Appeal Decision

Appeal Ref: APP/R4408/W/22/3309002

55 Market Street, Hoyland, Barnsley S74 0ET

- The appeal is made under section 78 of the Town and Country Planning Act 1990 against a refusal to grant outline planning permission.
 - The appeal is made by Mr Mick Lopia against the decision of Barnsley Metropolitan Borough Council.
 - The application Ref 2022/0344, dated 1 April 2022, was refused by notice dated 30 September 2022.
 - The development proposed is described as 'demolition of existing garage outbuilding and erection of 2no semi-detached dwellings and associated works including access from Rother Croft (Outline seeking approval over means of access and layout).'
-

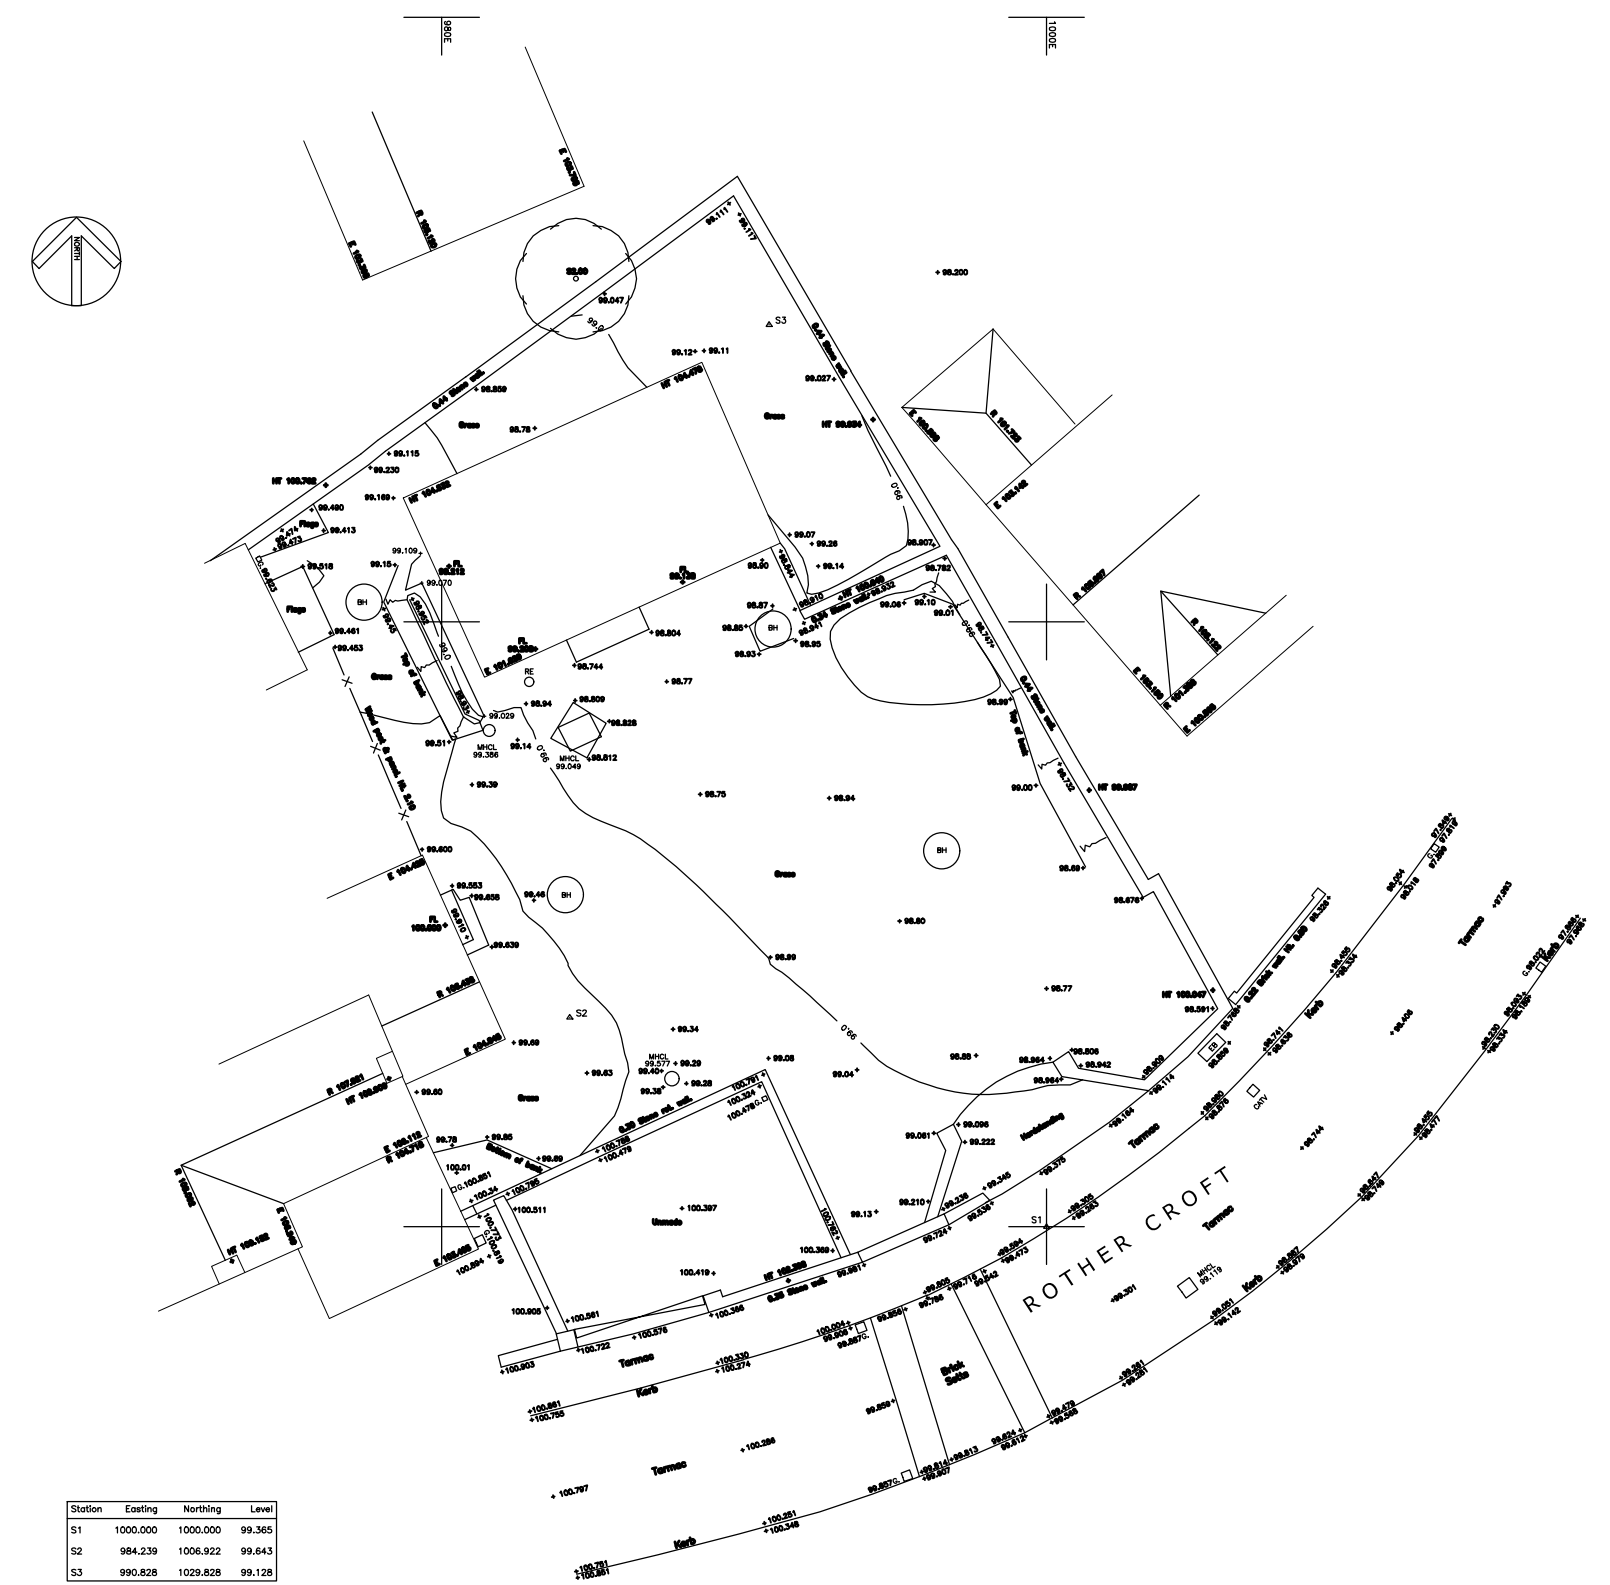
9. Whilst a feature of Rother Croft is parking at the front of the site, this is broken up, in part by boundary walls, hedging or lawns. The appeal site would, however, result in a wide frontage with a large open area of parking, in contrast to the traditional stone boundary wall that frames the current entrance way that I saw when I visited the site. This layout, required to provide parking and access would, however, mean that there is insufficient room for appropriate landscaping in this location. The extensive frontage, particularly when it is dominated by parked cars, would appear very open and detrimental to the visual harmony of the area.

10. The proposed plots would be in a similar alignment to the front building line of No 5 Rother Croft, whilst set back from the side extensions on the host property. Although it has been noted that there are a variety of house types within the area, detached housing is the prevalent house type in the immediate vicinity of the site. The proposed layout shows semi-detached properties.

11. Whilst semi-detached housing frequently sits alongside detached, two houses in a limited plot width would appear cramped. This is despite providing garden areas to the rear which would exceed the requirement of the Council's Design of Housing Development Supplementary Planning Document (SPD), 2019. This would likely appear more so because of the size and robust nature of the host dwelling, and indeed by the solid nature of the more modern properties within Rother Croft. Smaller dwellings would not be comparable with adjoining housing, and it would result in a pattern of development which would not be characteristic of that found in the area. Whilst the site is not in a Conservation Area, or has any other statutory designations, the siting of two houses in this location would cause harm to the character and appearance of the area.

14. The proposal would be built parallel to the rear elevations of the house. Although there is some disagreement as to where distances should be measured to, it would be 9 metres from the rear two storey extension on the host property, with the Council's SPD recommending 12 metres between dwellings. Despite this, the distance between the rear of No 55 and the pair of dwellings, would provide a reasonable gap which would not appear overbearing to the occupiers of No 55. This, combined with the extensive area to the front of the house, plus the space around the building derived from it being in a corner plot, would mean that the proposal site could be developed without having an adverse impact on the setting of the host.

19. As an outline application with no indicative drawings of scale, it is not possible to be certain over the degree of any overlooking that a dwelling, which in this case would be plot 2, would have over the occupiers using the garden room of No 5. I noted that the existing garage at No 55 which would be demolished, does at present provide a degree of privacy over the garden room and the rear garden area. However, without this, and the differences in ground level, the privacy of No 5 is likely to be harmed.

20. The position of the proposal in relation to the garden room at No 5 would also have the potential to result in a loss of sunlight to the garden room and the rear garden area. This, again, would be exacerbated by the difference in height between the two sites and the effect that housing on the site would cause. Although the appellant considers that as the application only relates to matters of access and layout, overshadowing should not 'bear much weight' at this stage, it has not been demonstrated that a pair of dwellings of an appropriate design could be built without affecting No 5. Therefore, I conclude that the proposal would harm the living conditions of the occupiers of No 5 Rother Croft with regard to privacy and sunlight and would not accord with LP Policy GD1 and the SPD.
